Our ref: HA/2024/125722/05-L01
Your ref: AL/11/24/OUT
Date: 04 April 2025

FURTHER MODELLING INFORMATION SUBMITTED - HYBRID APPLICATION CONSISTING OF: 1) OUTLINE PERMISSION FOR ALL MATTERS RESERVED (EXCEPT ACCESS) FOR UP TO 400 NO DWELLINGS AND ASSOCIATED WORKS AND 2) FULL PLANNING PERMISSION FOR ALTERATIONS TO SITE ACCESS OFF WESTERGATE STREET AND THROUGH PINE CLOSE AND EAST-WEST LINK ROAD INCLUDING A BRIDGE OVER THE LIDSEY RIFE. THIS APPLICATION ALSO LIES WITHIN THE PARISH OF BARNHAM, FALLS WITHIN STRATEGIC SITE SD5, CIL ZONE 1 (ZERO RATED), AFFECTS THE SETTING OF LISTED BUILDINGS, AFFECTS THE CHARACTER AND APPEARANCE OF THE EASTERGATE CHURCH LANE CONSERVATION AREA, AFFECTS PUBLIC RIGHTS OF WAY. THIS APPLICATION IS THE SUBJECT OF AN ENVIRONMENTAL STATEMENT LAND EAST OF WESTERGATE WESTERGATE

Environment Agency position

PLAN
SCALE 1:100
30000 (CLEAR SPAN)

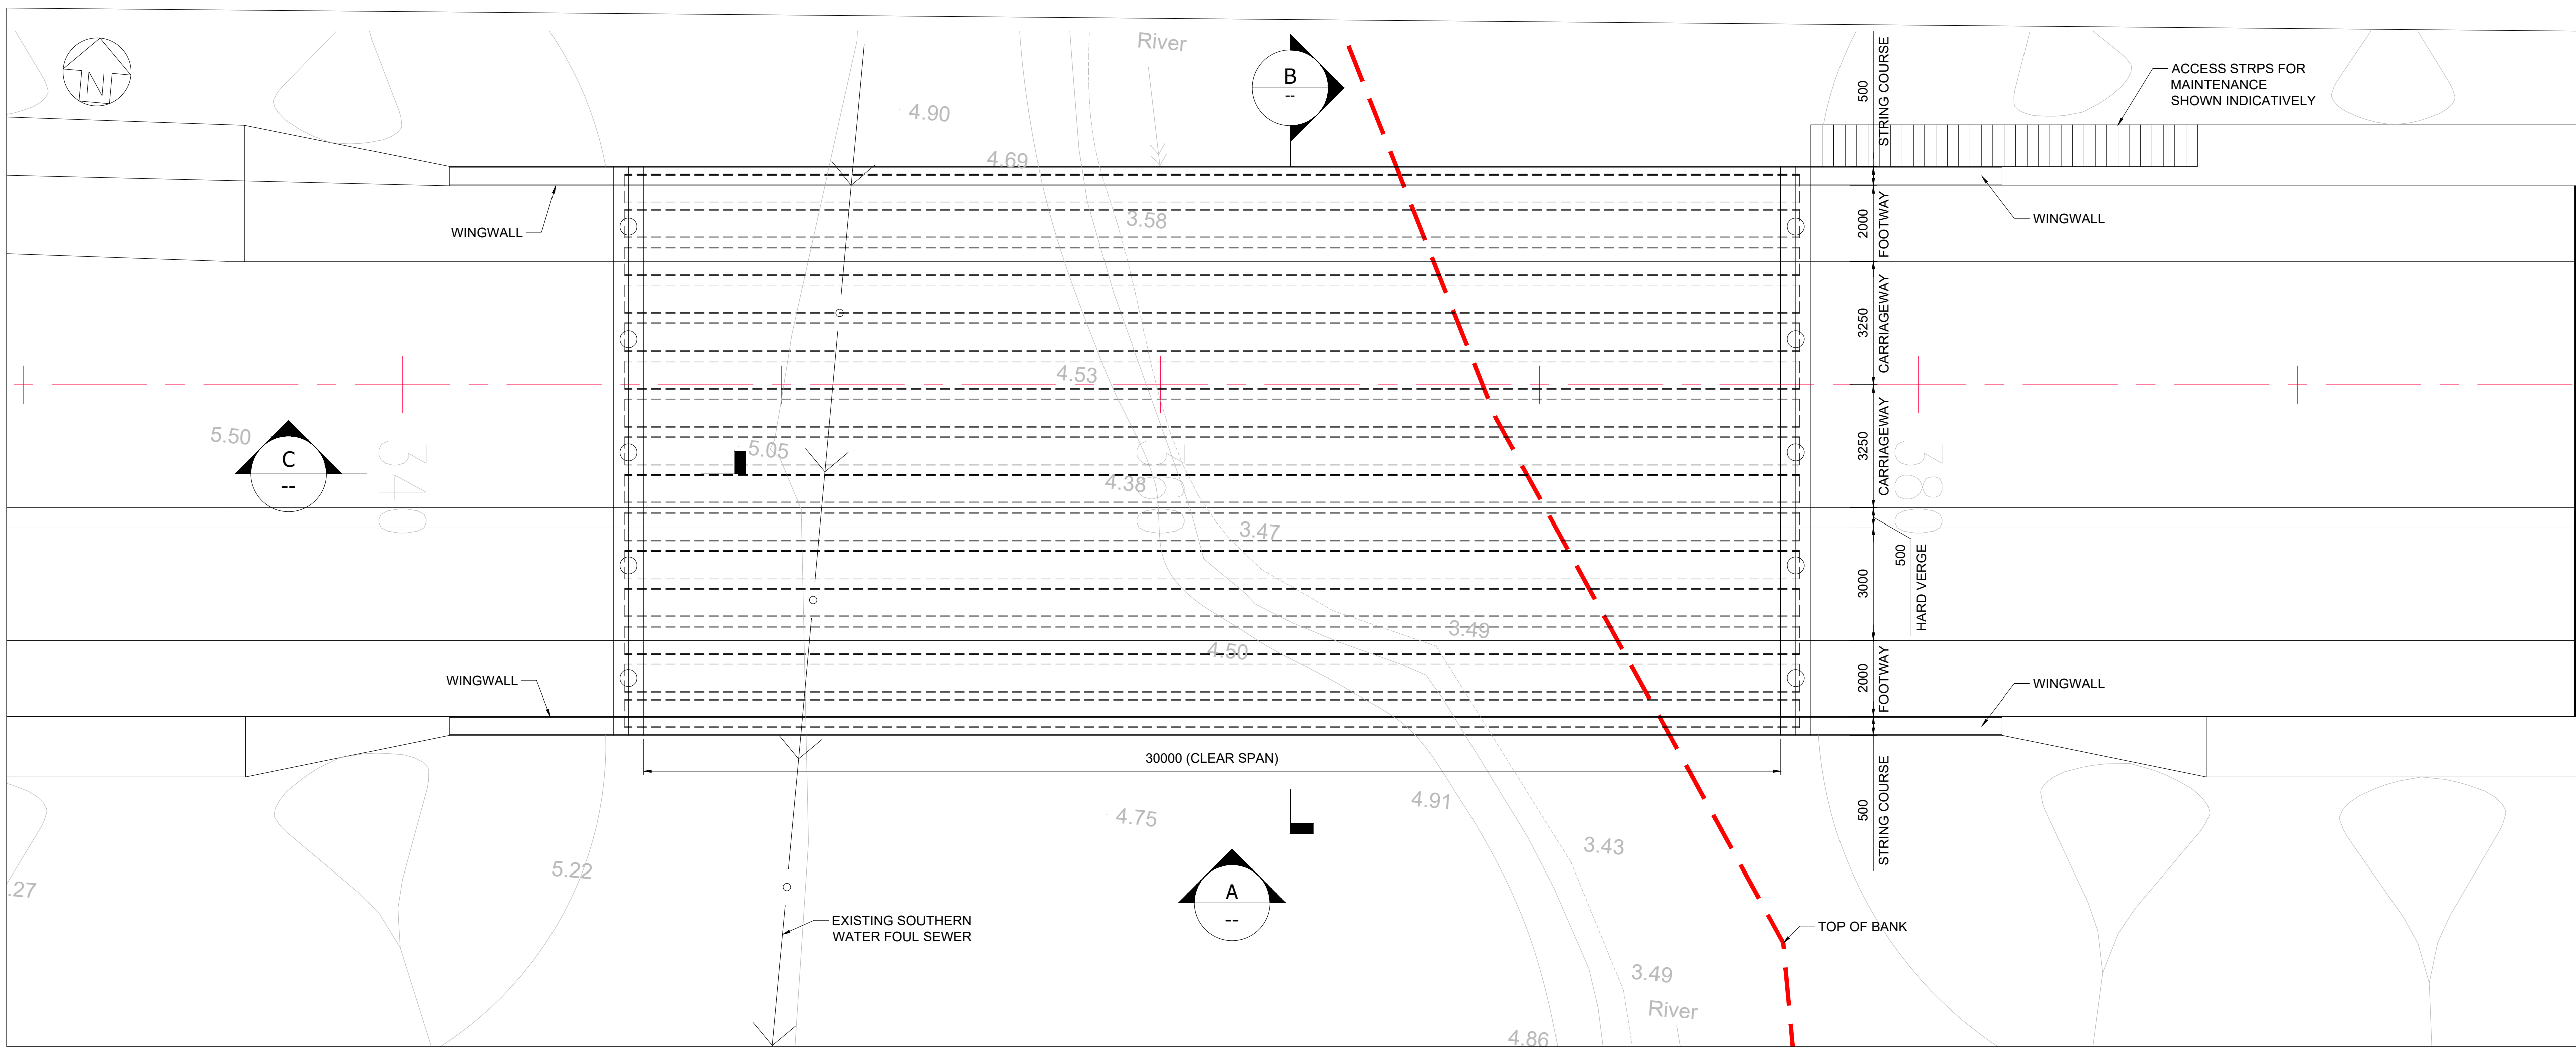
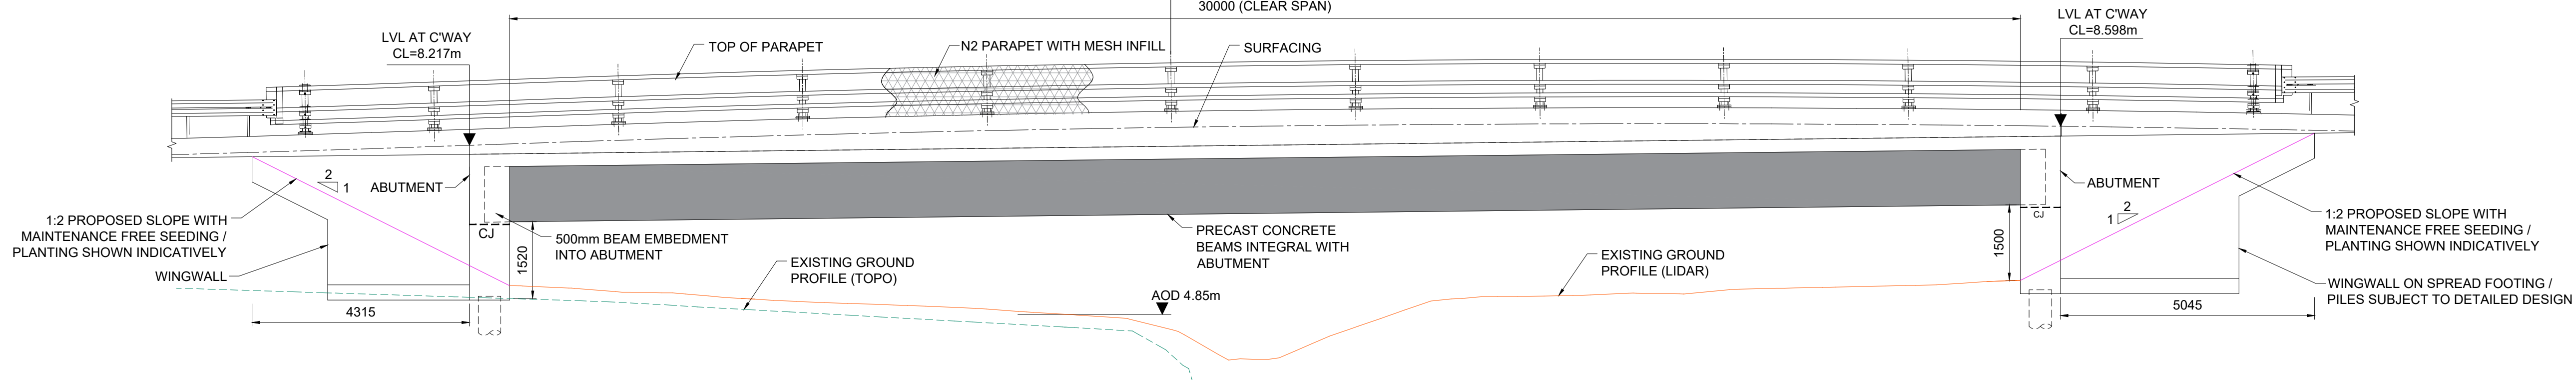
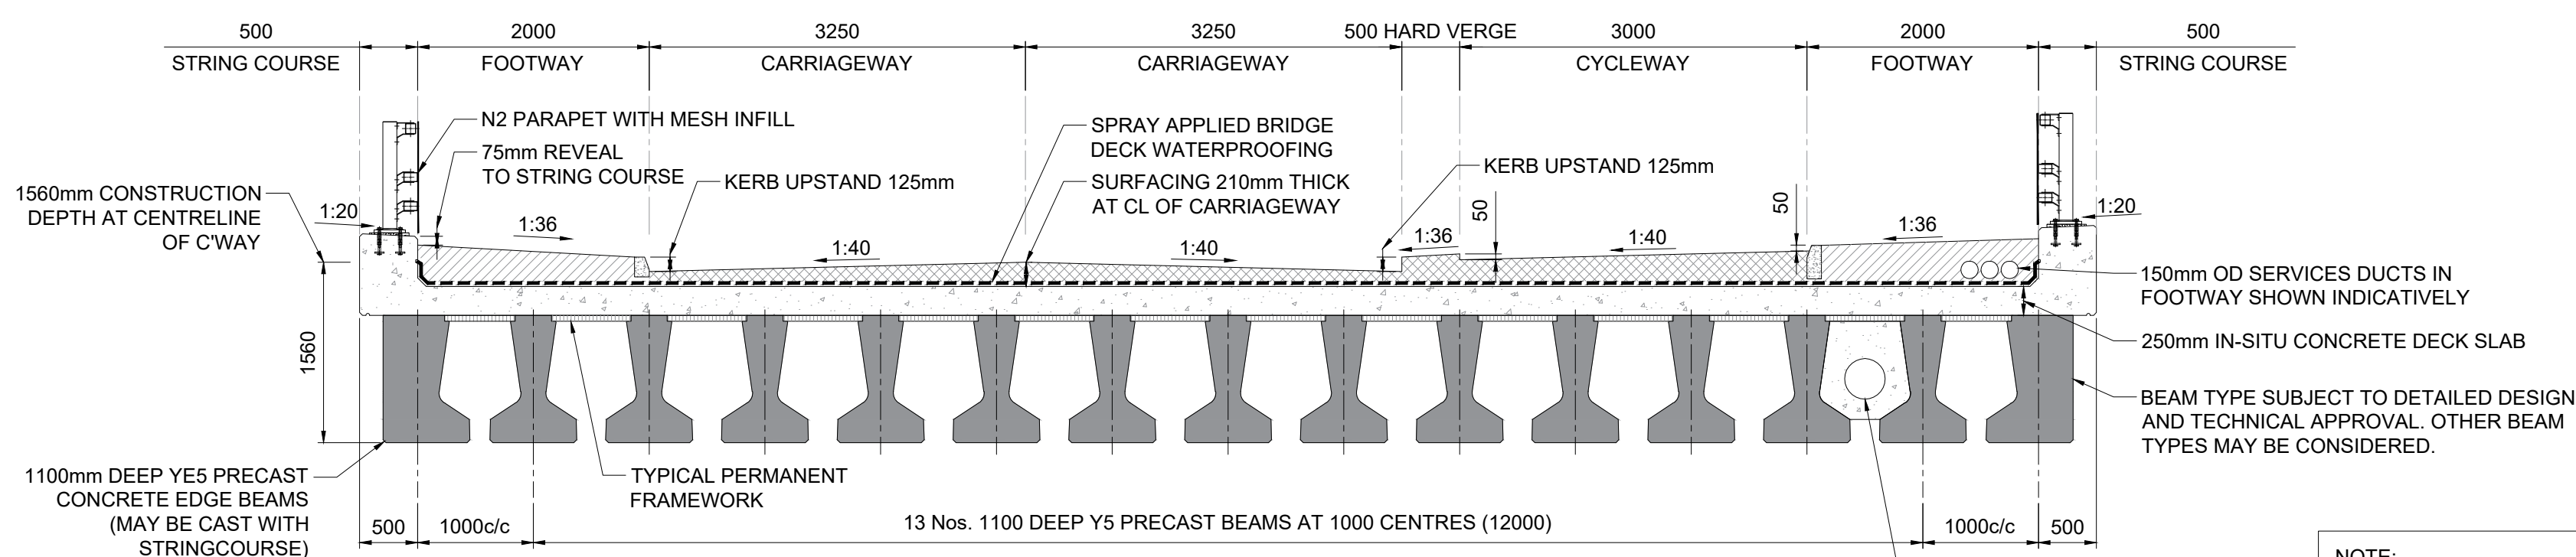
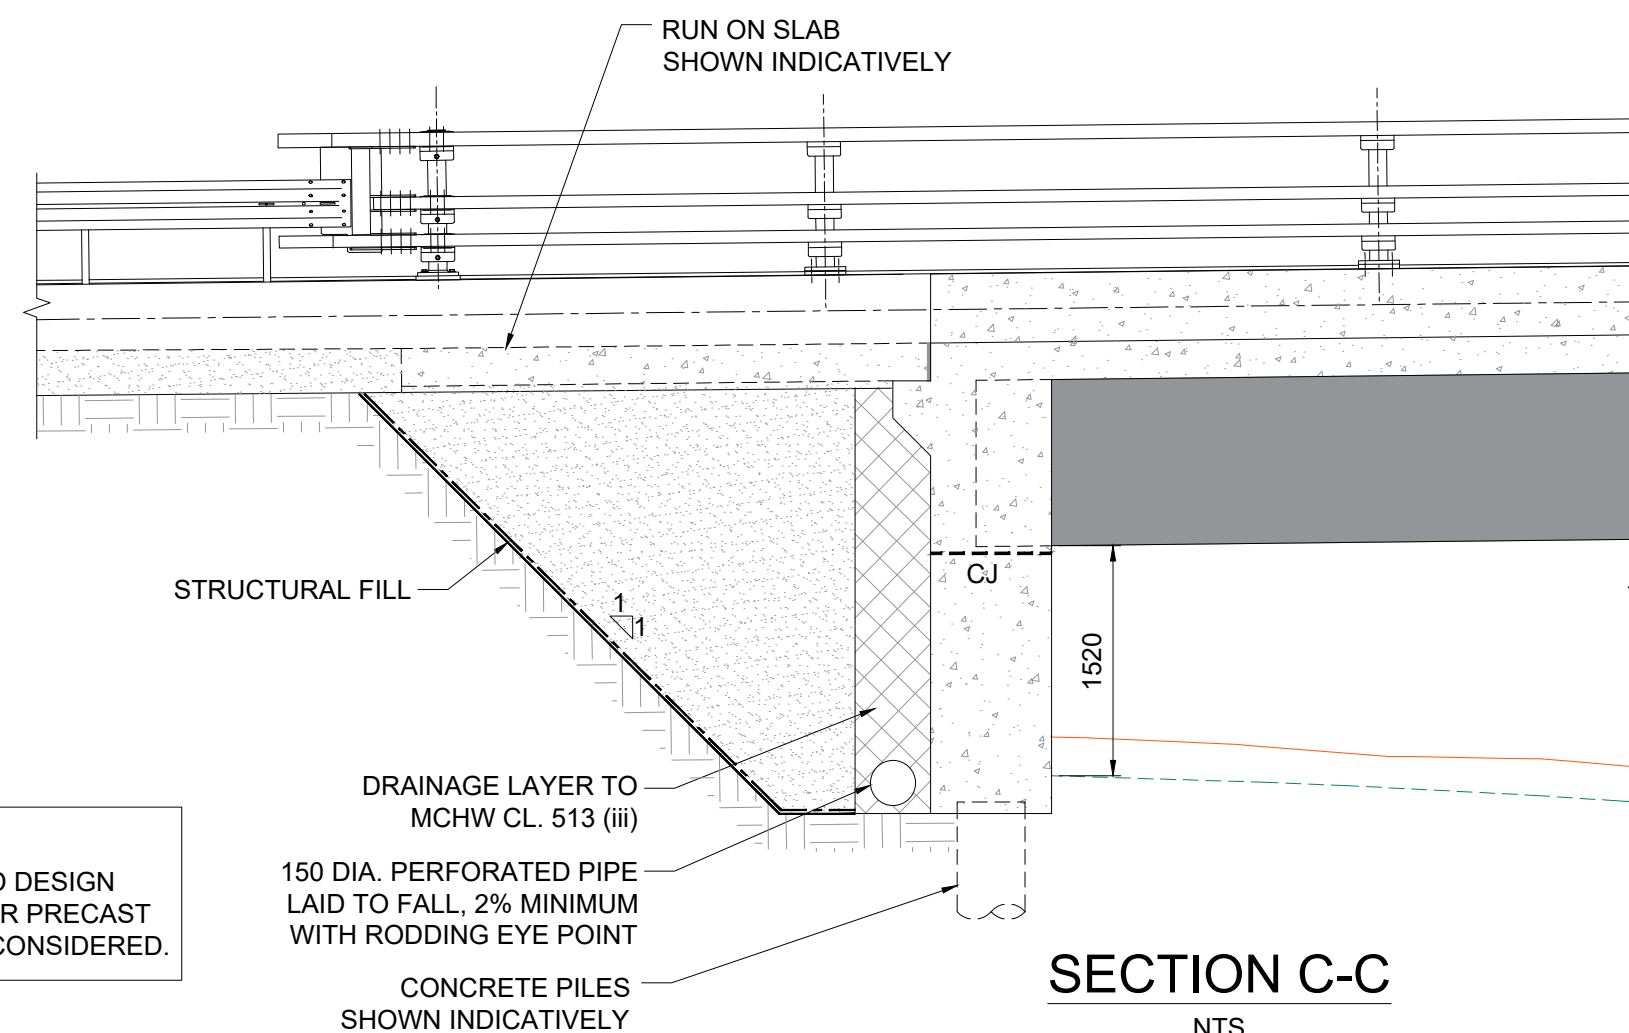
A sensitivity test has been undertaken for baseflow on Westergate Stream with results presented in the supplied March 2025 Addendum report. It is noted that there may be future design changes to the proposed bridge on Westergate Stream. If further modelling is being undertaken to assess this, it is recommended that baseflow/an initial water level is included on Westergate Stream to better understand potential impacts in this area.

‘Addendum 2 to the Hydraulic modelling report – February 2025’ states, *“Although the modelling does demonstrate very small increases in flood levels as a result of the proposed crossing over the Lidsey Rife, we would like to propose that the same compensation storage is provided, in accordance with your agreed volumes with the adjacent proposed development. Our development and the adjacent proposed development share the proposed crossing over the Lidsey Rife and we will work together to ensure that level to level compensation storage is provided in areas outside the 100 year plus climate change envelope.”* No details of the proposed floodplain compensation has been provided.

The signed off model shows that there is a need for floodplain compensation.

To overcome our objection, the applicant should submit a revised FRA which addresses the points highlighted above, includes a detailed plan to deliver the appropriate level of floodplain compensation.
